ITEM 1.3(c)

Issue/ Objection:
Natural Ventilation

85 Harrington Street
The Rocks
GOLDEN AGE & HANNAS THE ROCKS

TITLE
RESPONSE TO DoPE
ITEM 1.3(c)

TITLE
**Diagrams
 Cross Vent**

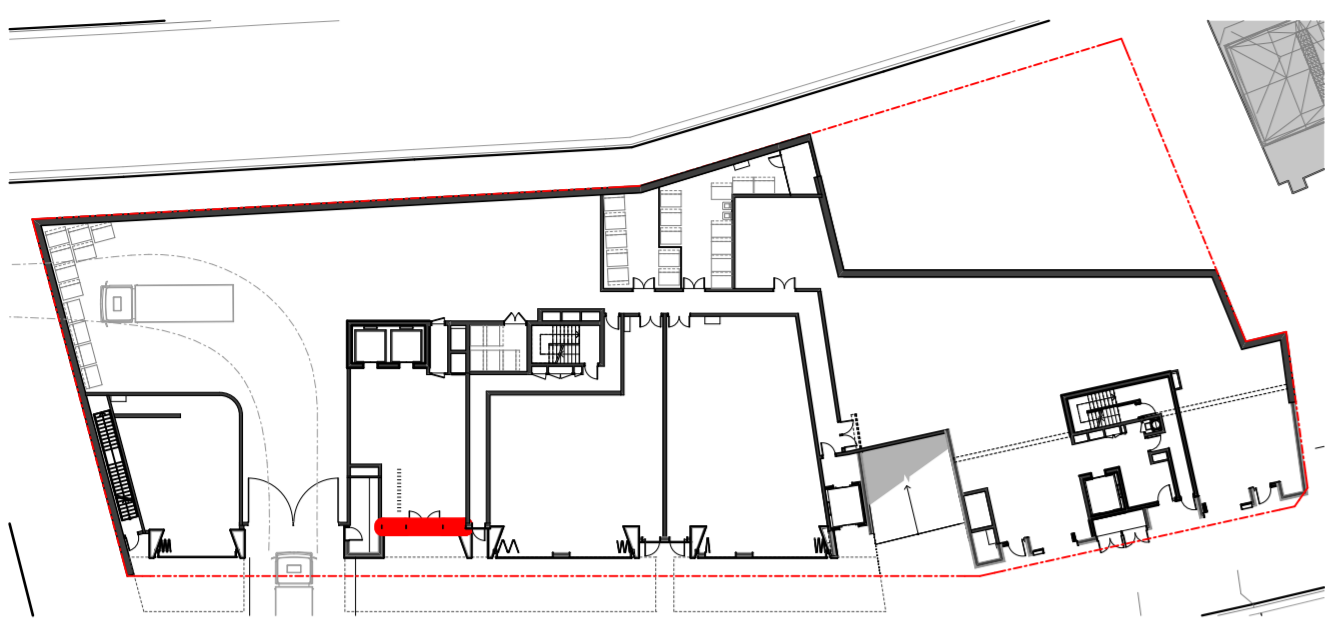
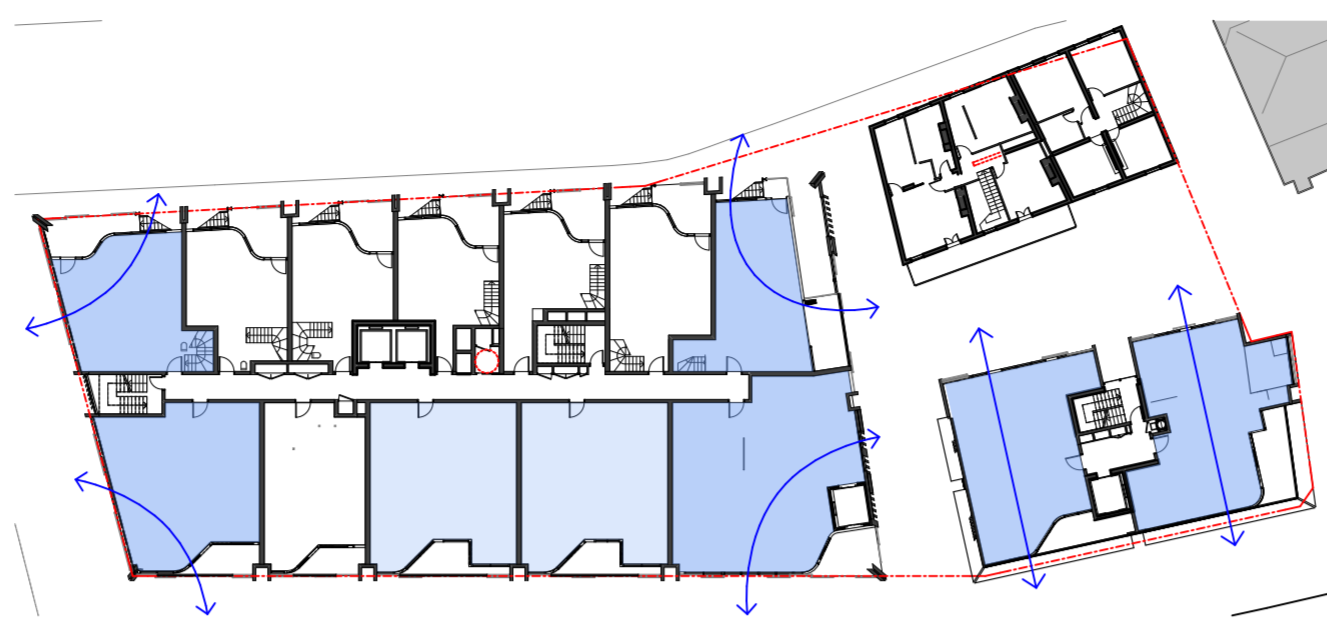
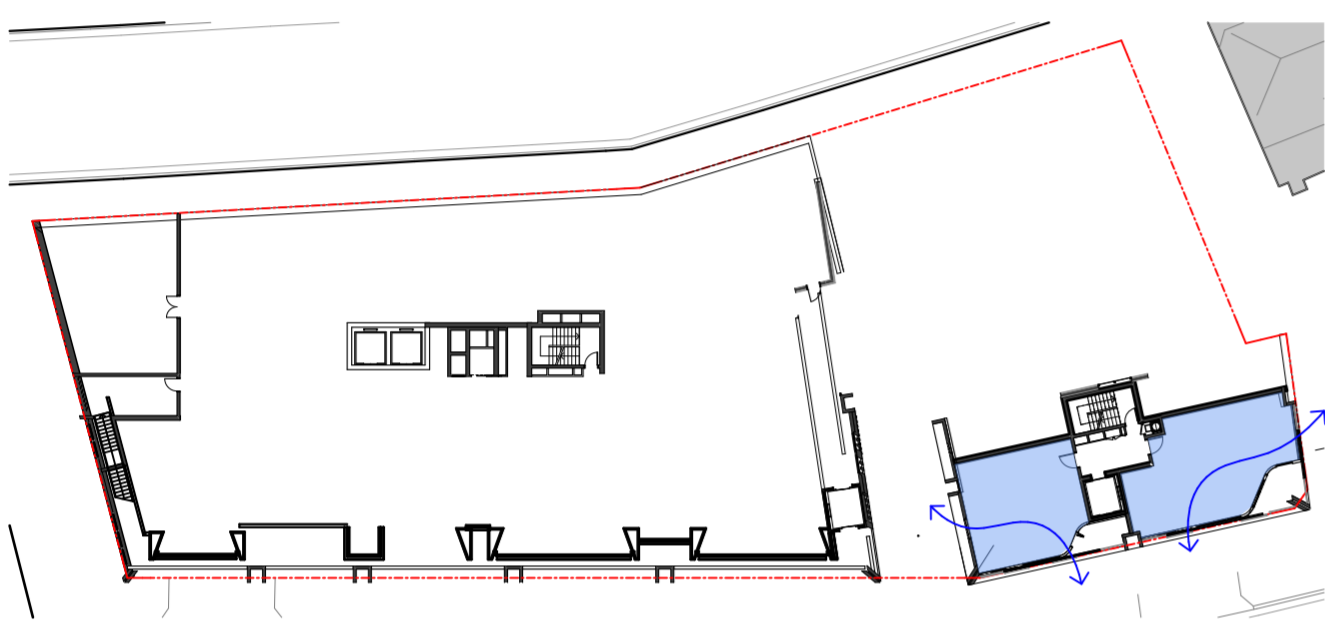
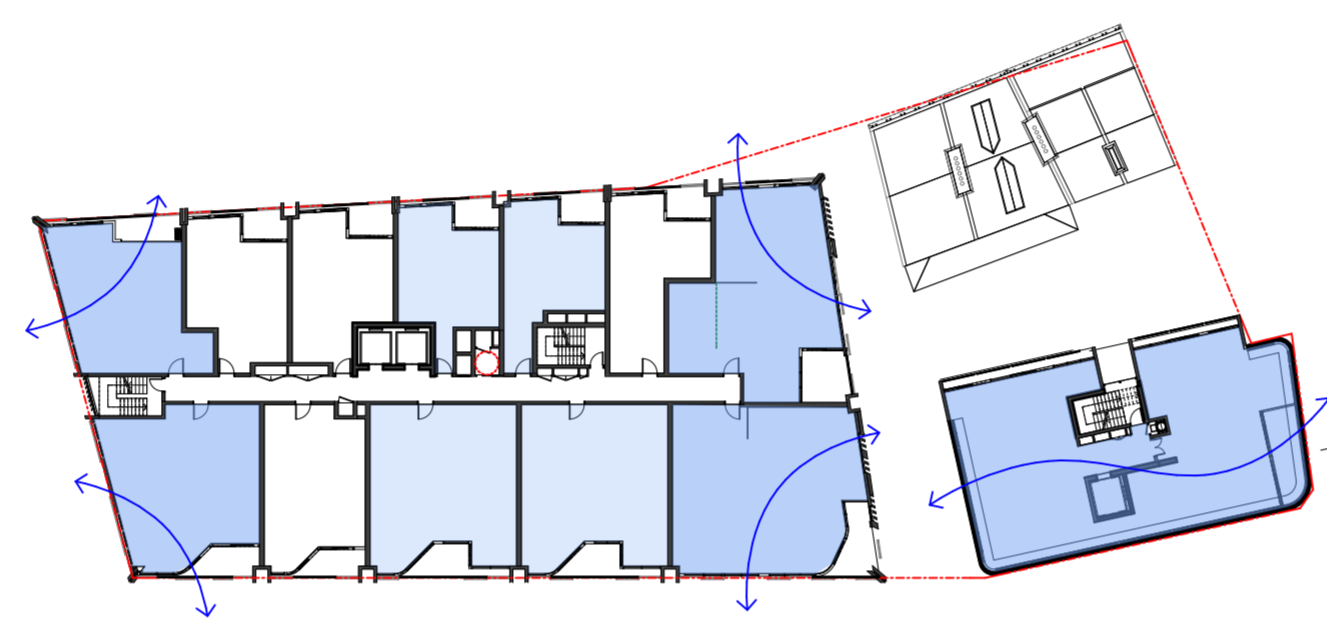
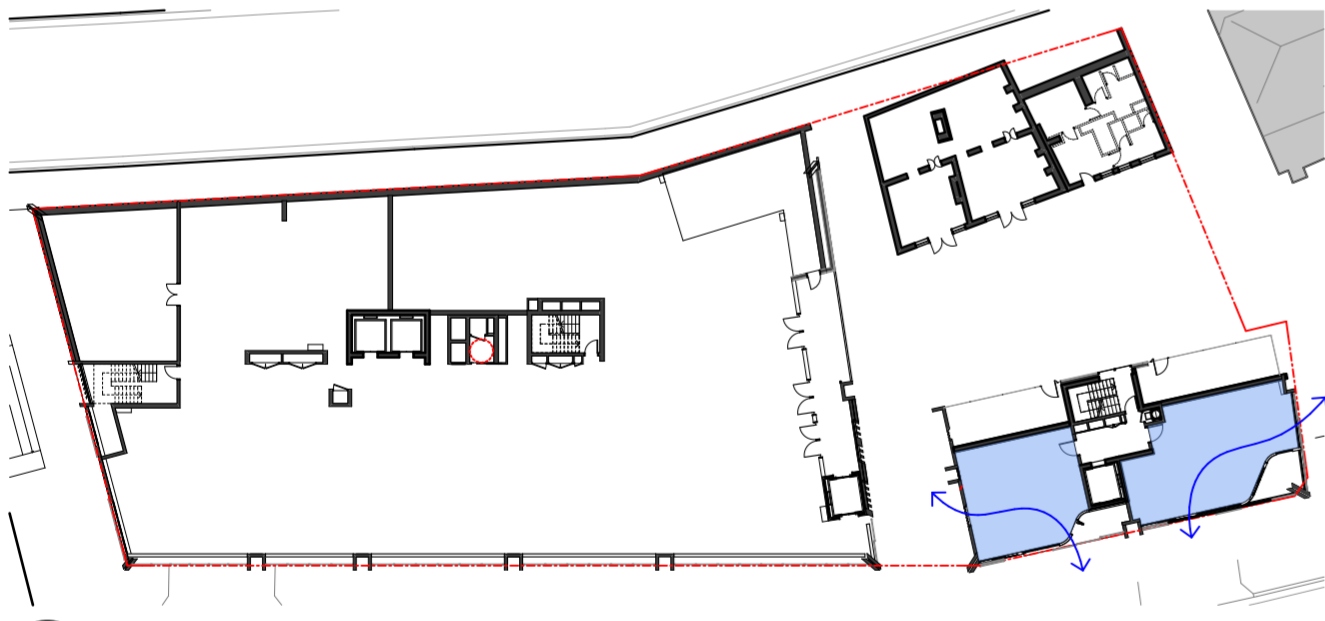
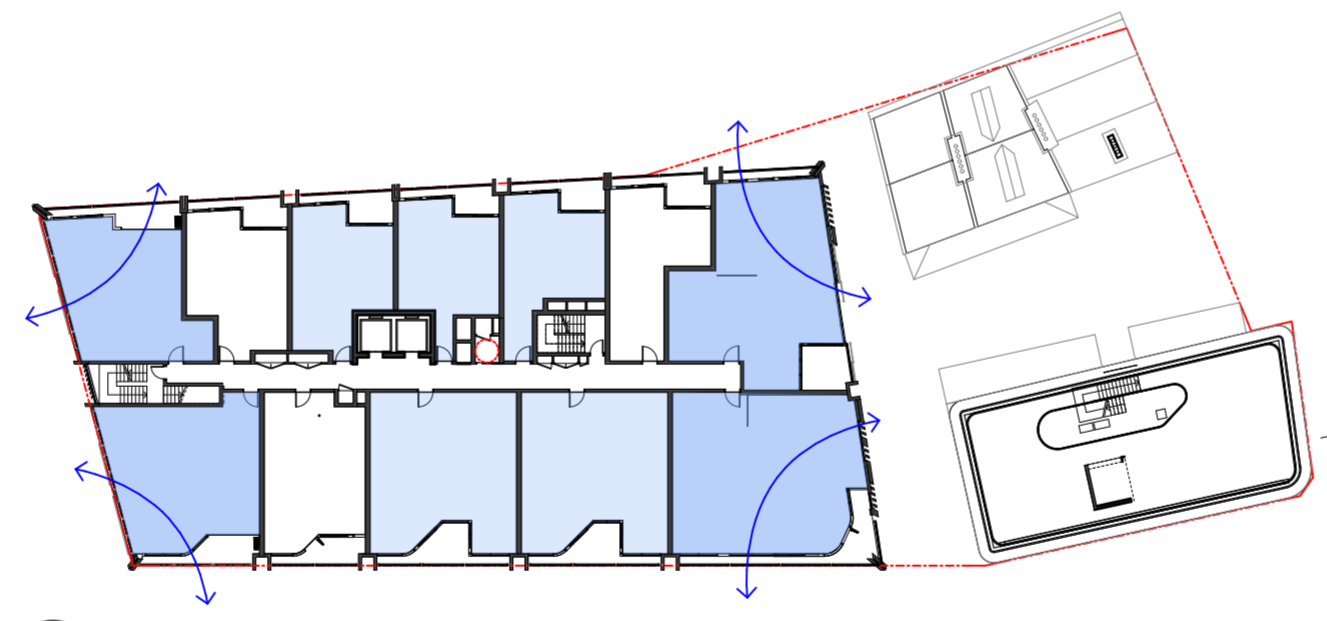
Description:
The proposal includes the five single aspect maisonette units as achieving natural cross ventilation. Further evidence is required demonstrating how these units achieve natural cross ventilation. Consideration should also be given to alternative dieting solutions for non-cross ventilated units to improve natural ventilation.

Response
29 Apartments achieve compliance as per the apartment design guide's (ADG) definition of natural cross ventilation. 5 Apartments achieve cross ventilation as detailed in qualitative assessments undertaken by ARUP. Refer to all additional information prepared by ARUP.
